NOTES FROM INFORMAL COUNCIL PRE-DA MEETING

**PROPOSED RESIDENTIAL SUBDIVISION OF LAND AT CORNER CHIFLEY ROAD AND
 MORISSET PARK ROAD, MORISSET PARK
 (LOT 9 DP 244002 AND LOT 358 DP 755242)**

LAKE MACQUARIE CITY COUNCIL

10.00AM TO 10.45AM – TUESDAY, 4 DECEMBER 2007

STORMWATER DETENTION BASIN PLAN

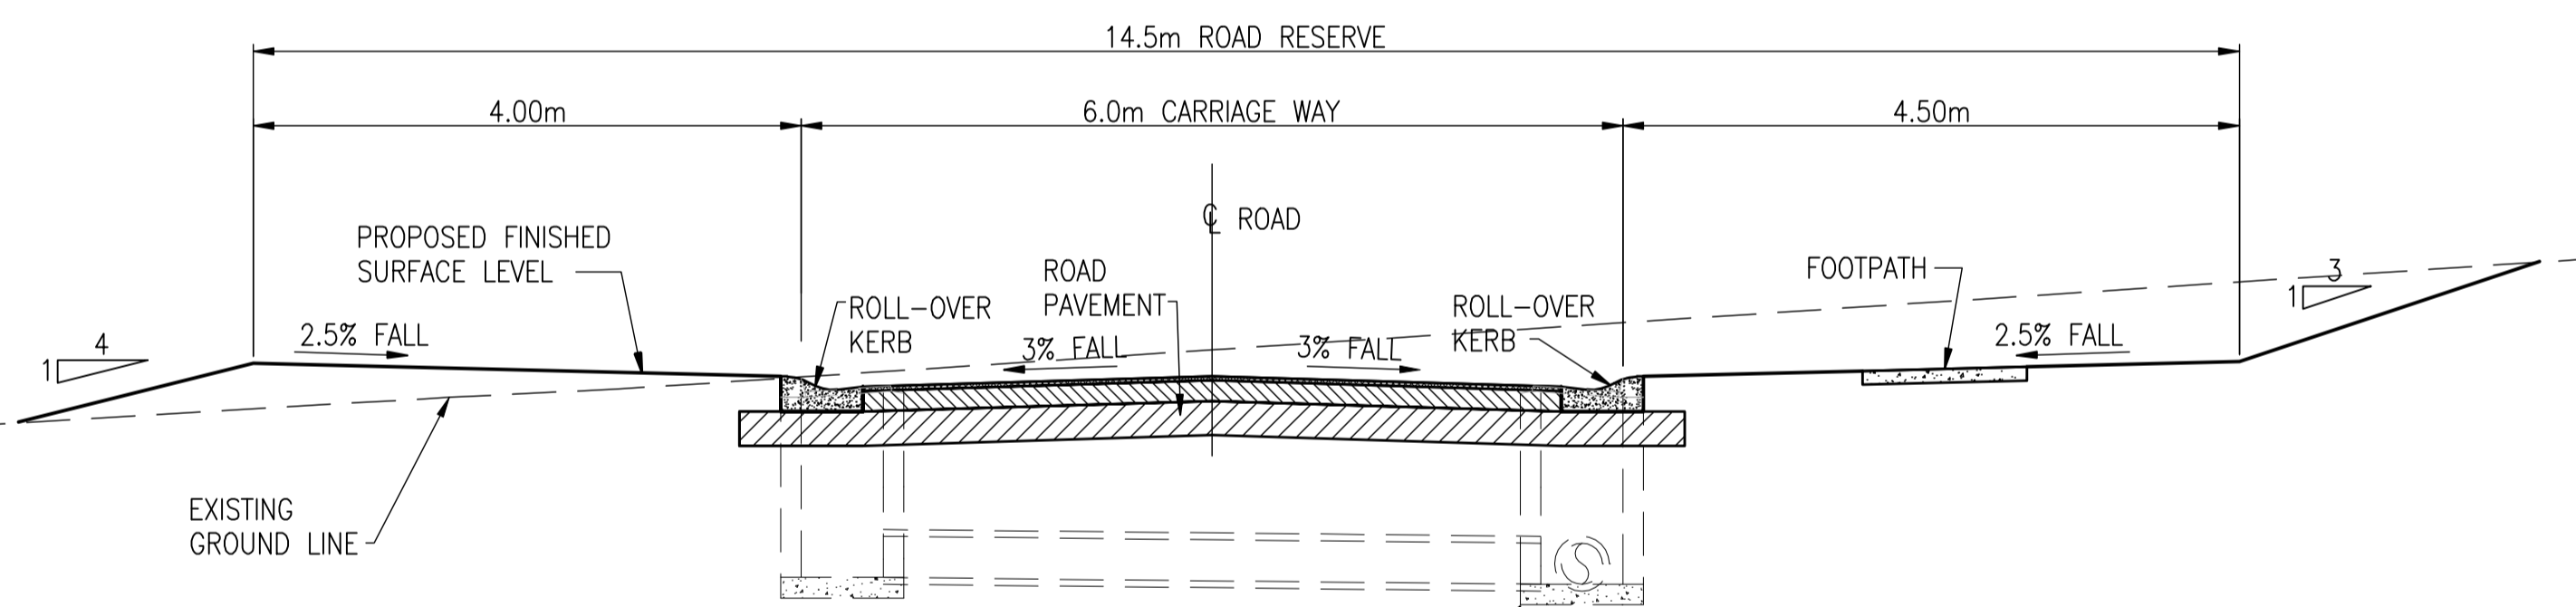
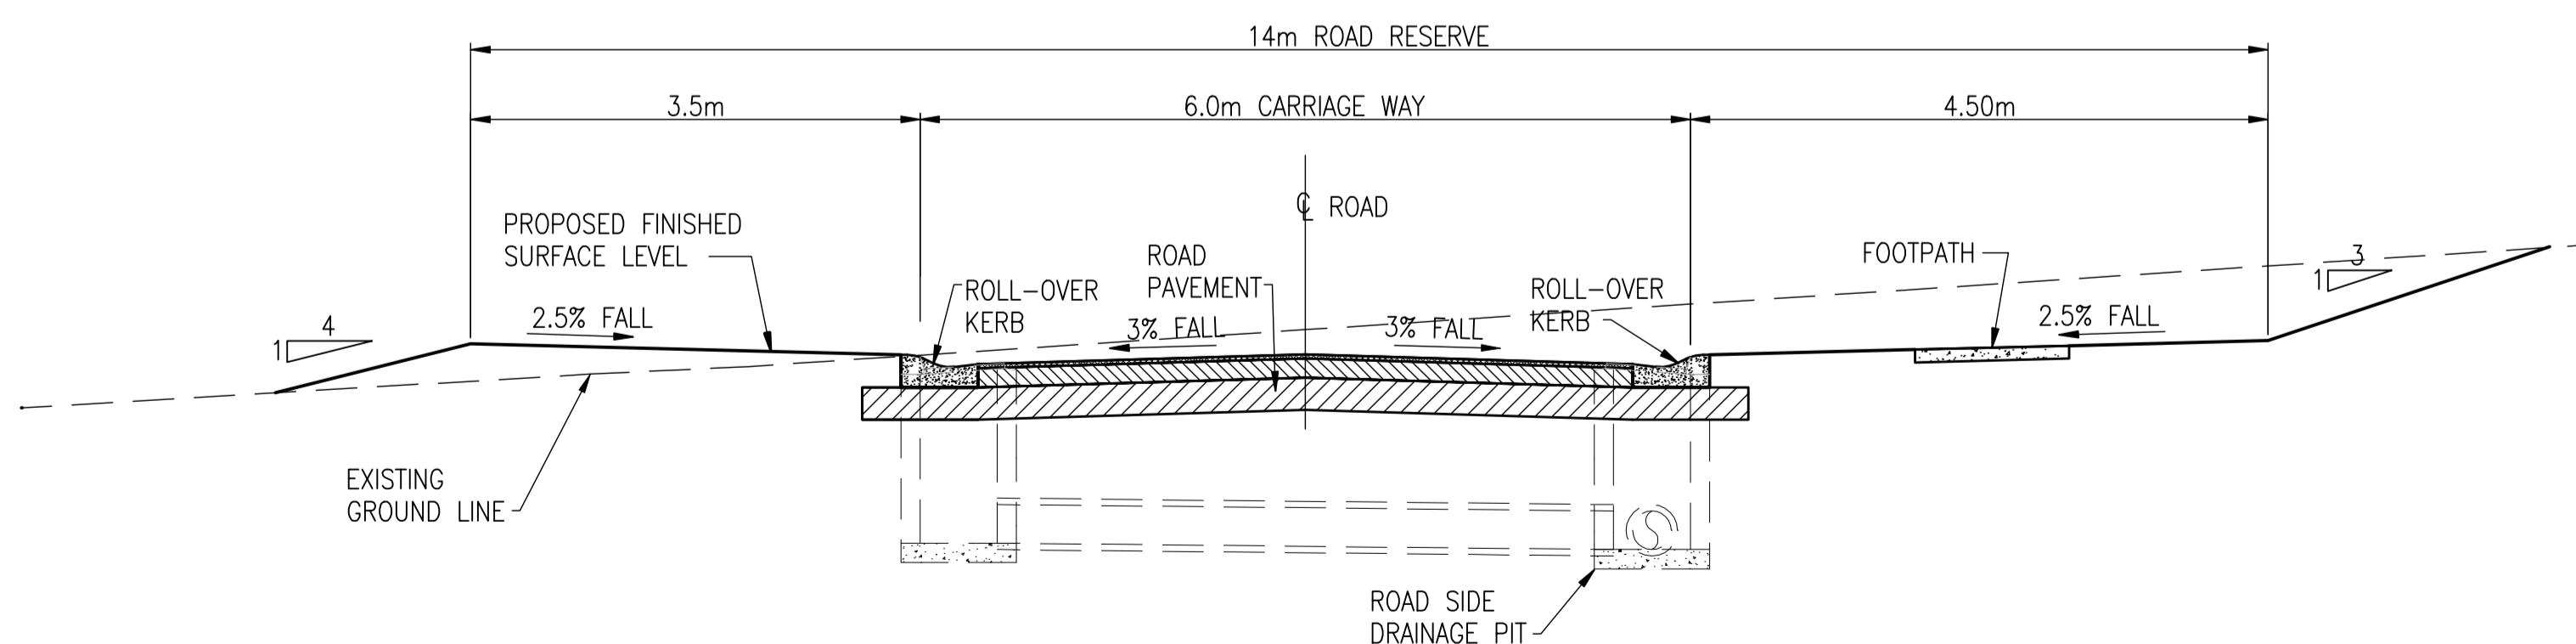
5.	<p>GF advised that overall he was supportive of the proposed residential subdivision layout.</p>	Noted.
6.	<p>GF advised that the existing easement for drainage between proposed Lot 72 (detention basin) and Chifley Street would need to accommodate any emergency overflow. This may require certain physical works which should be discussed with the landowner prior to DA lodgement.</p>	De Witt Consulting to liaise with landowner and Northrop Engineers.

ROAD1 From ch0.000 To ch340.000 Scales: H 1 in500 V 1 in100

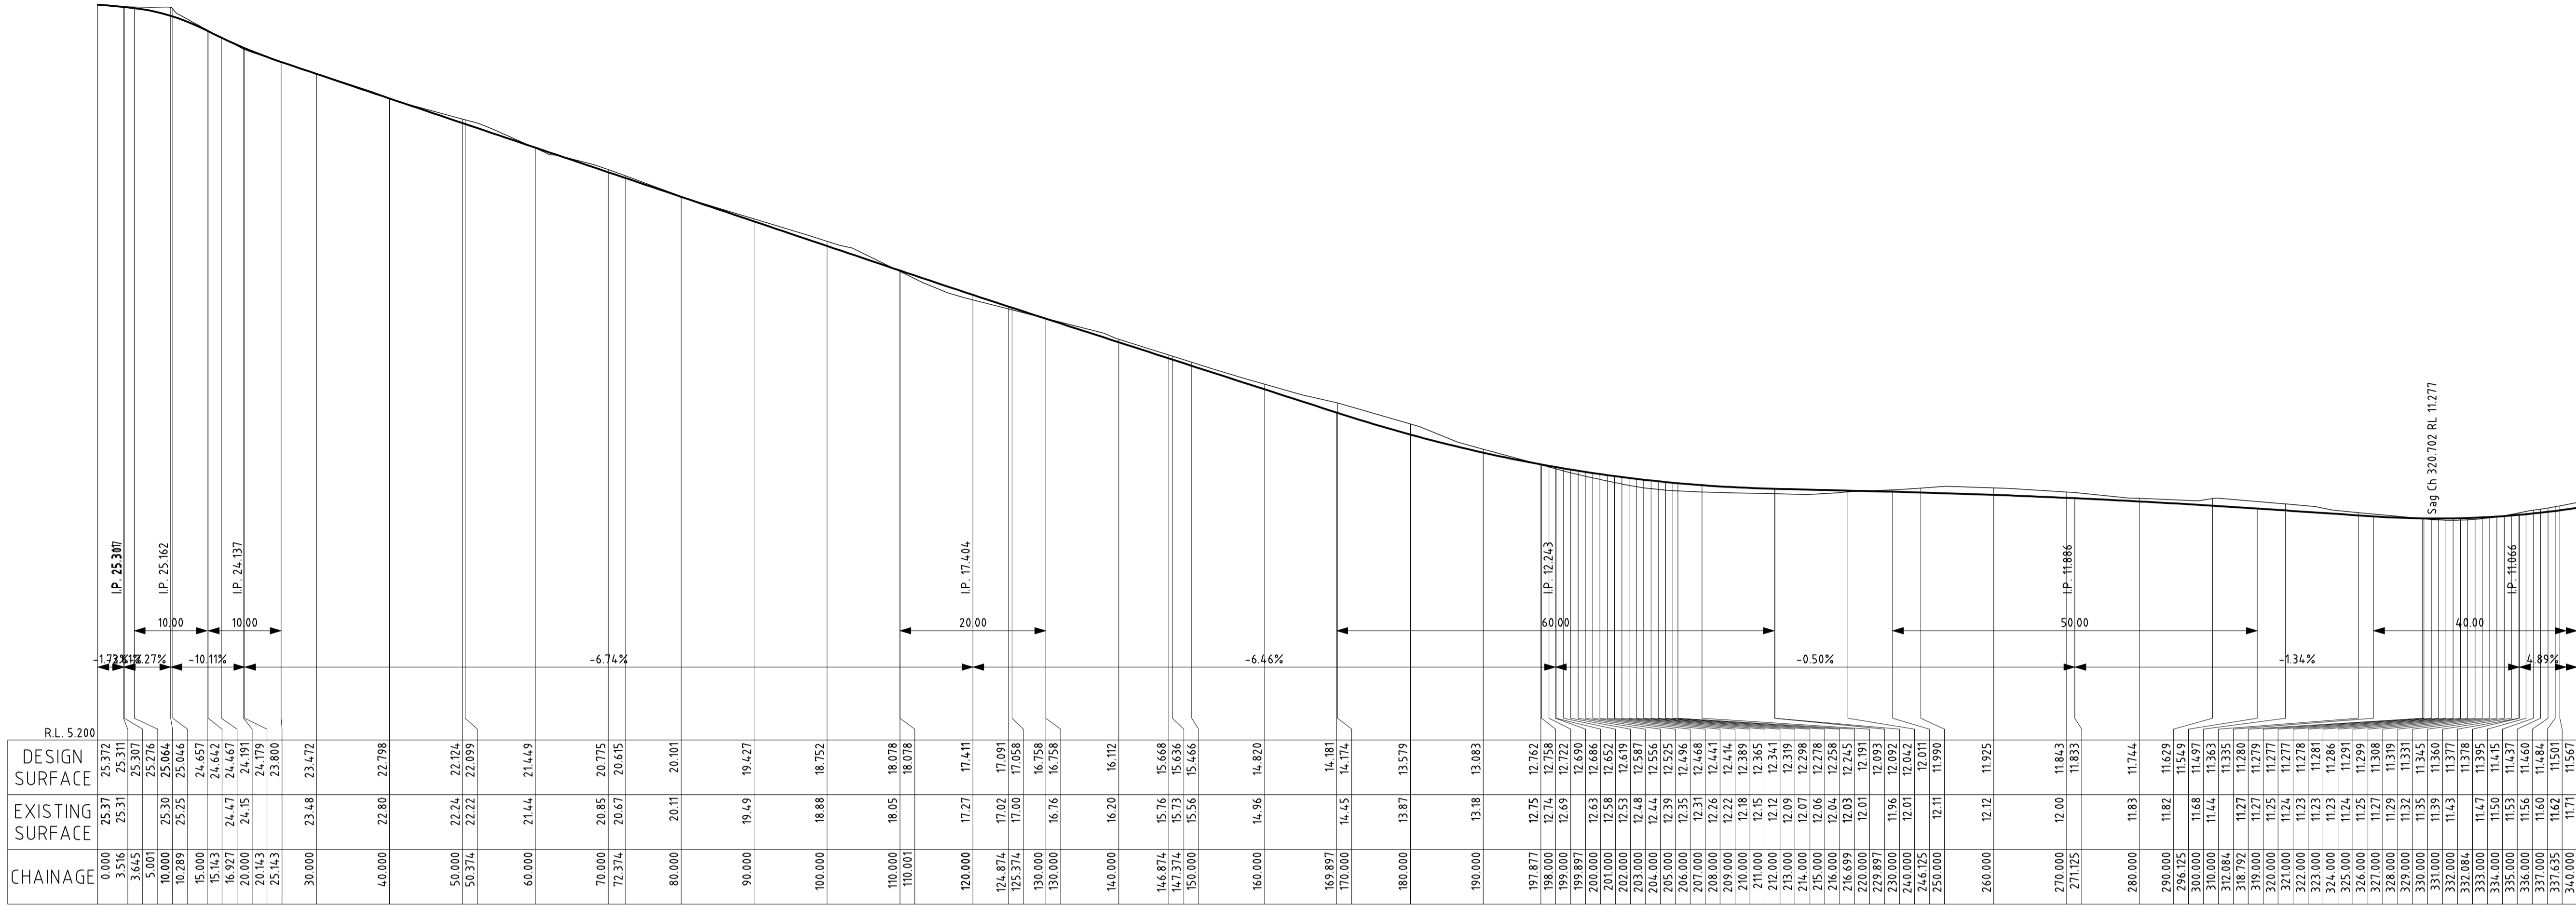
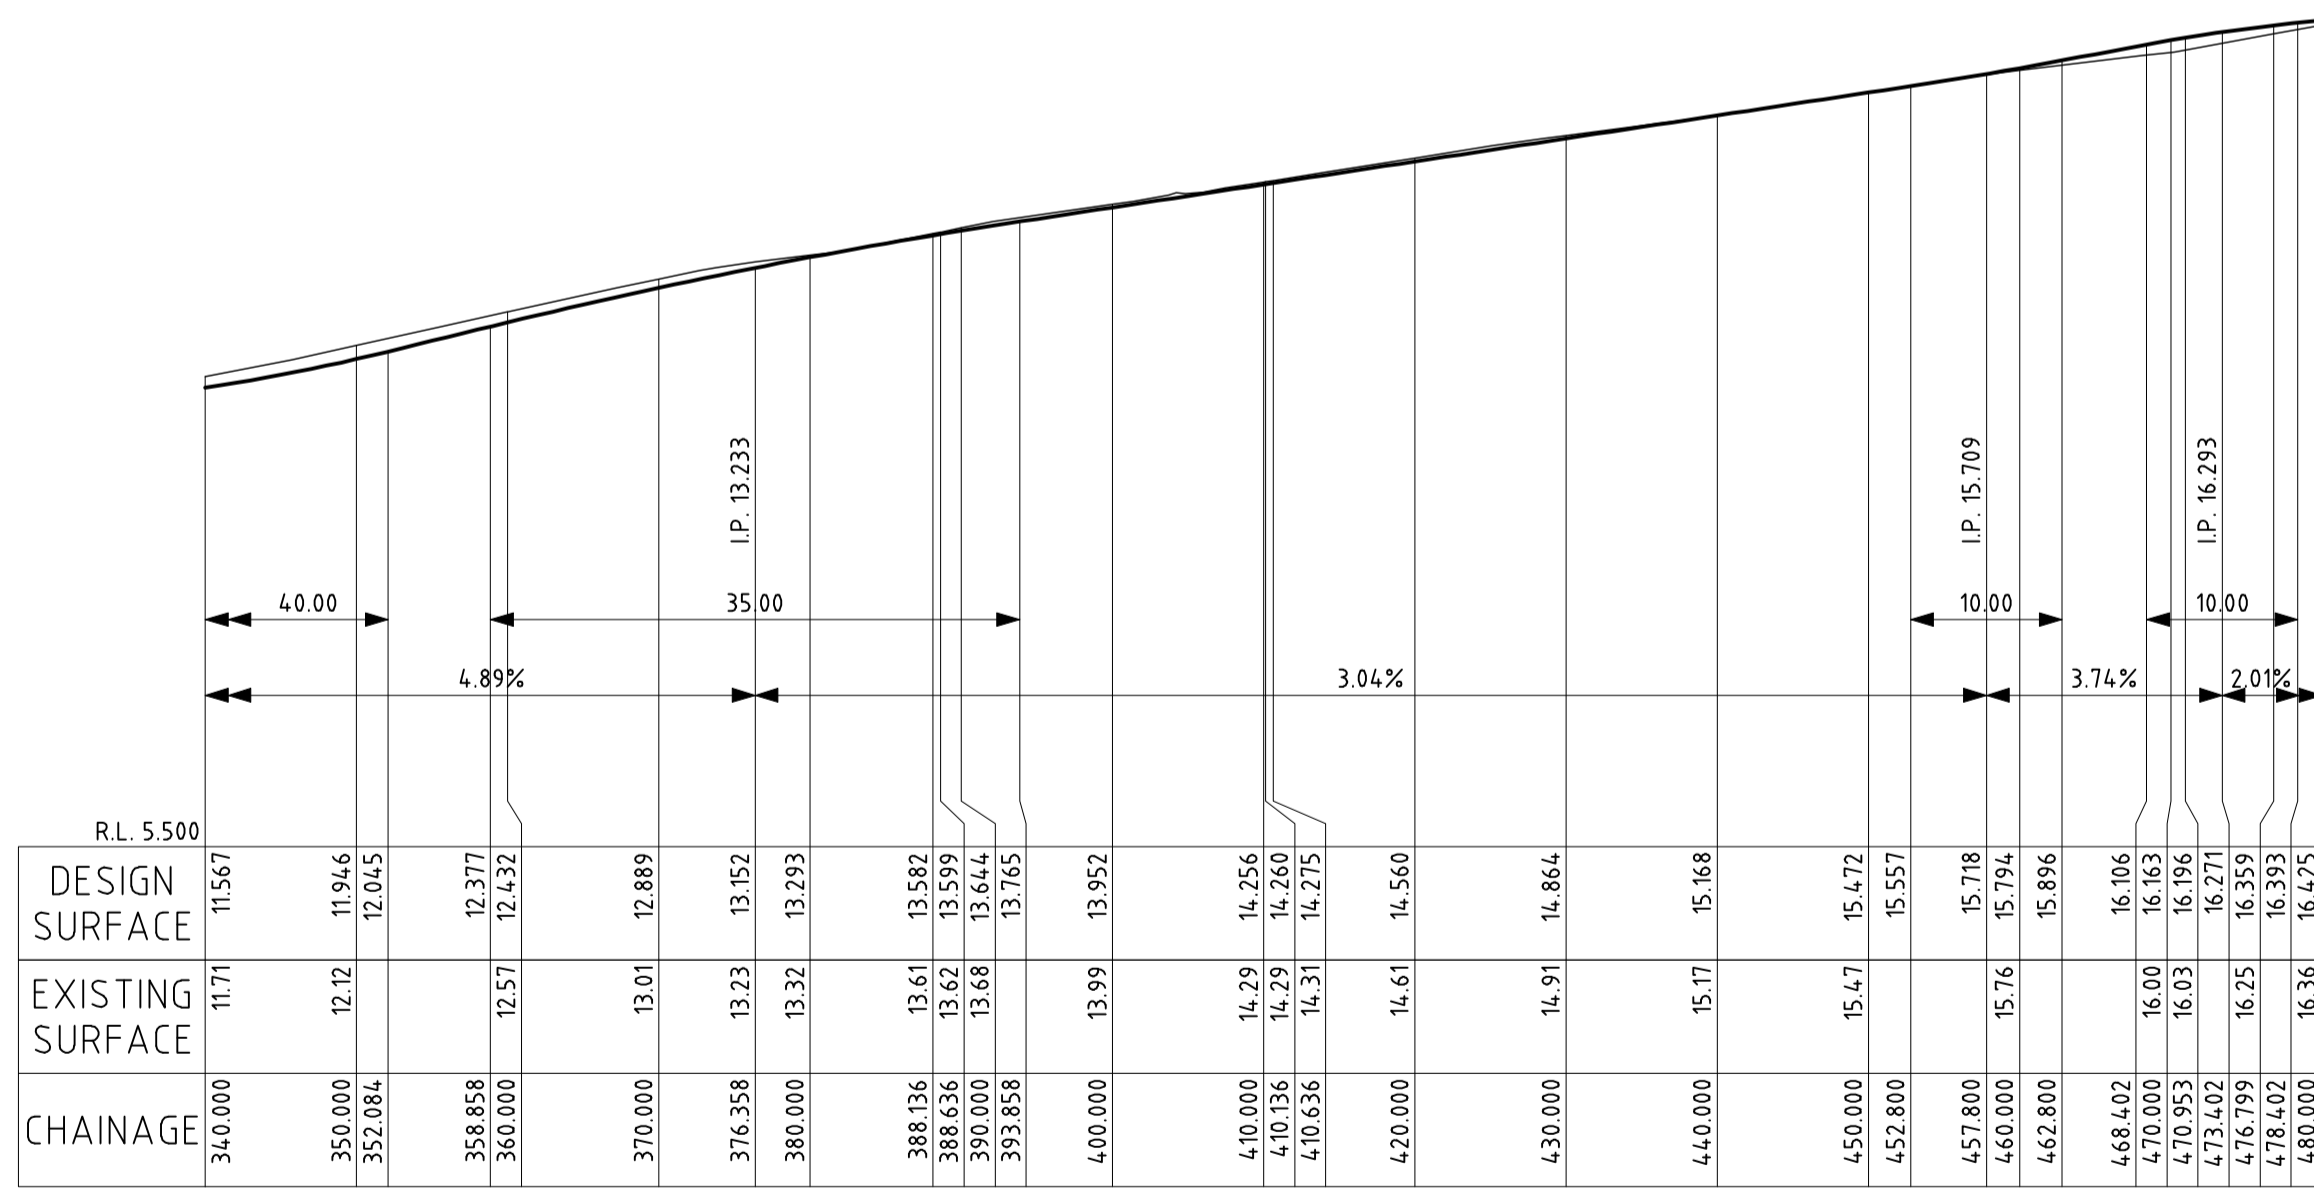
9.	<p>GF advised that the DA should identify any regrading required along the Morisset Park Road frontage.</p>	Noted.
10.	<p>GF advised that the 14m and 14.5m wide roads proposed were satisfactory.</p>	Noted.
